Our Ref: BE/3/20/HH

**Town & Country Planning Act 1990 (as amended)
Town & Country Planning (Development Management Procedure) (England) Order 2015
Application for Householder Planning Permission**

Development Two storey side extension
Location 3 Central Avenue Bersted

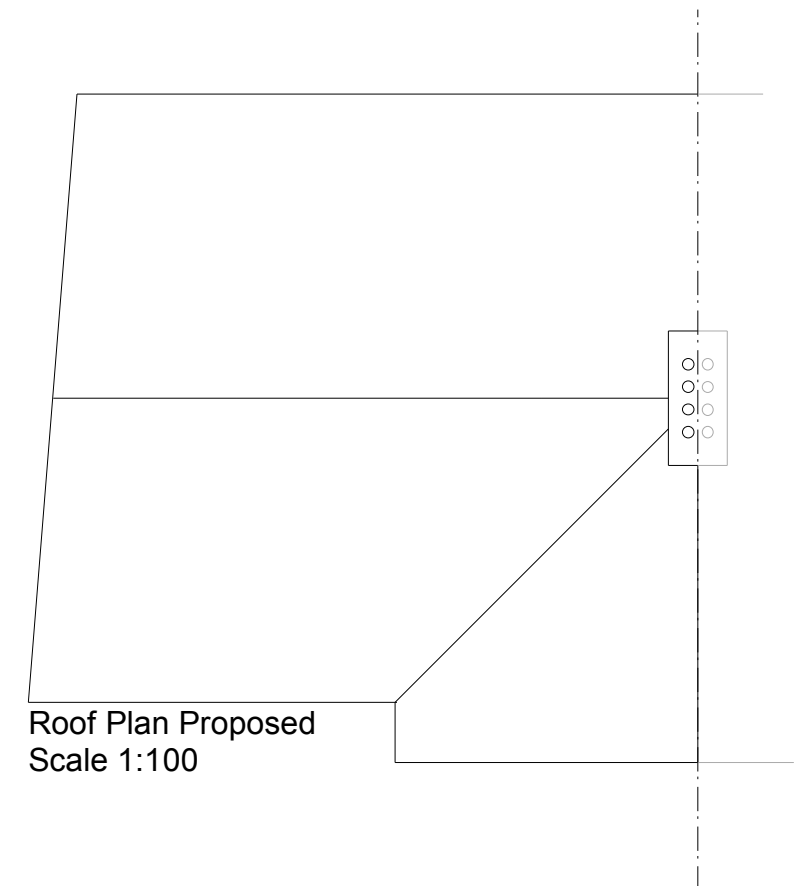
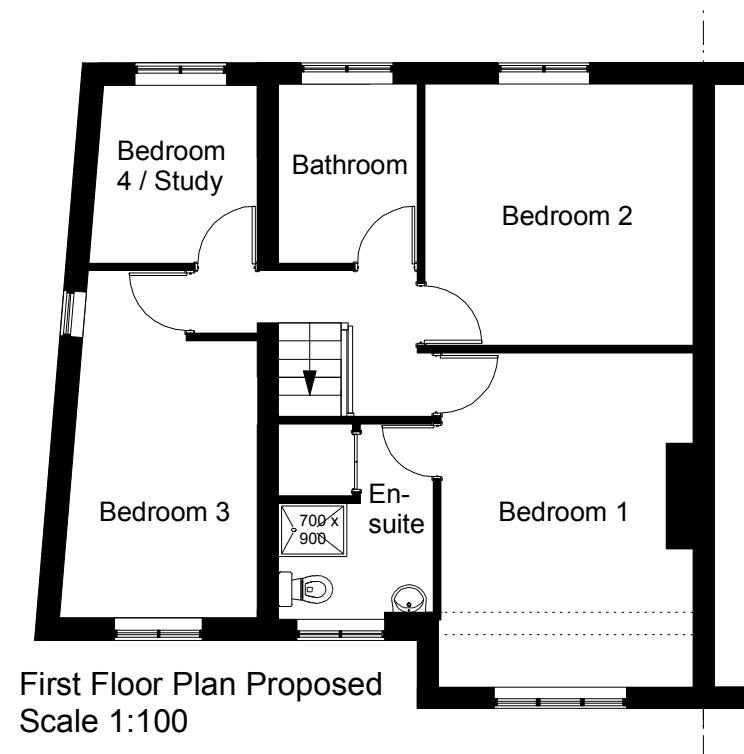
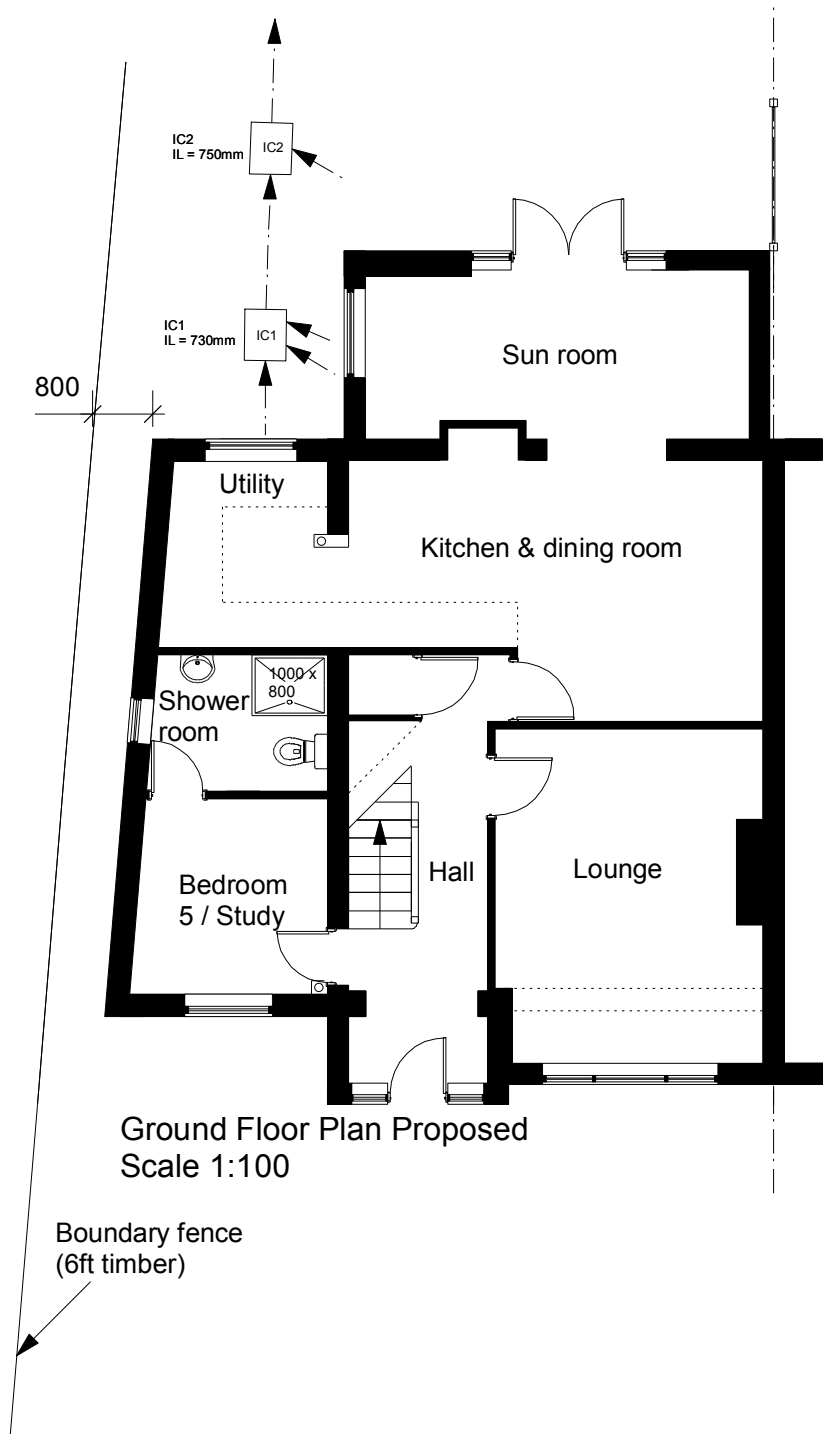
Inconsistent: The size and shape of the extension is inconsistent between the block plan and proposed plans.

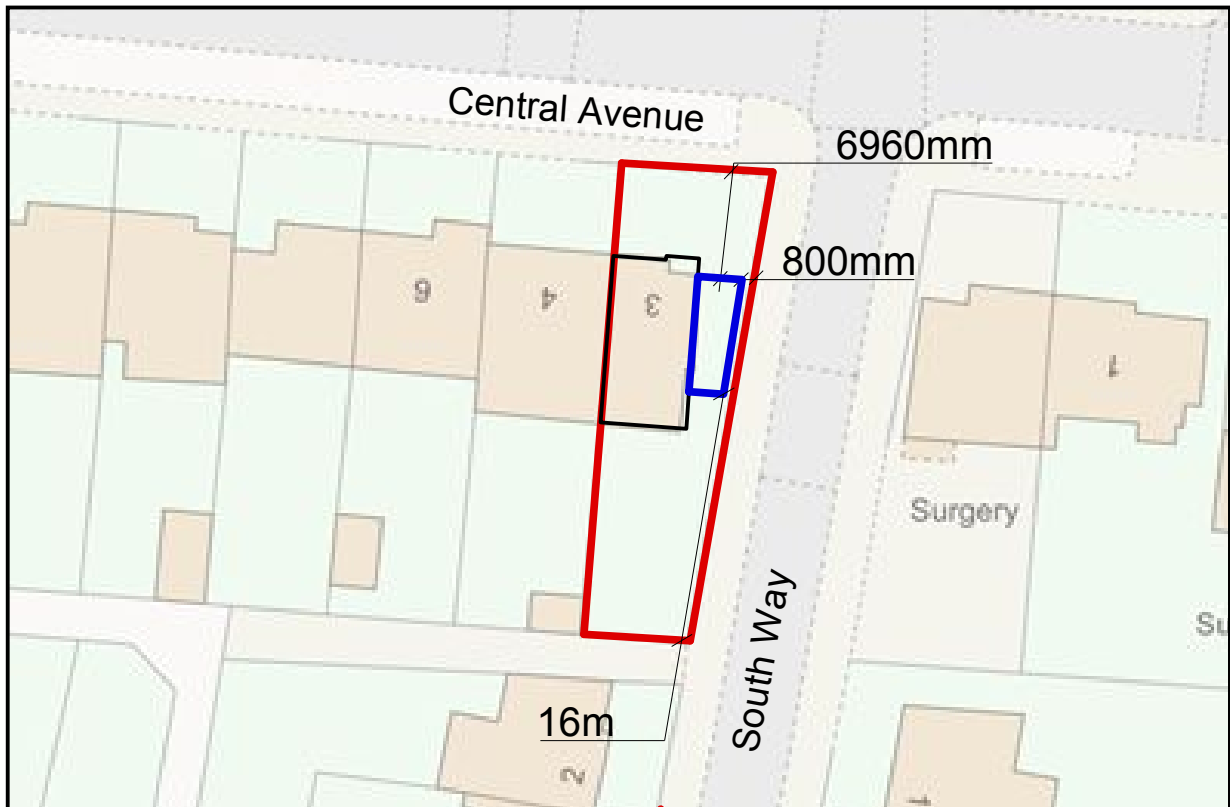
Block Plan: You are required to have dimensions to all site boundaries. Currently the one to the rear boundary is missing, please amend or with your permission we can add it for you.
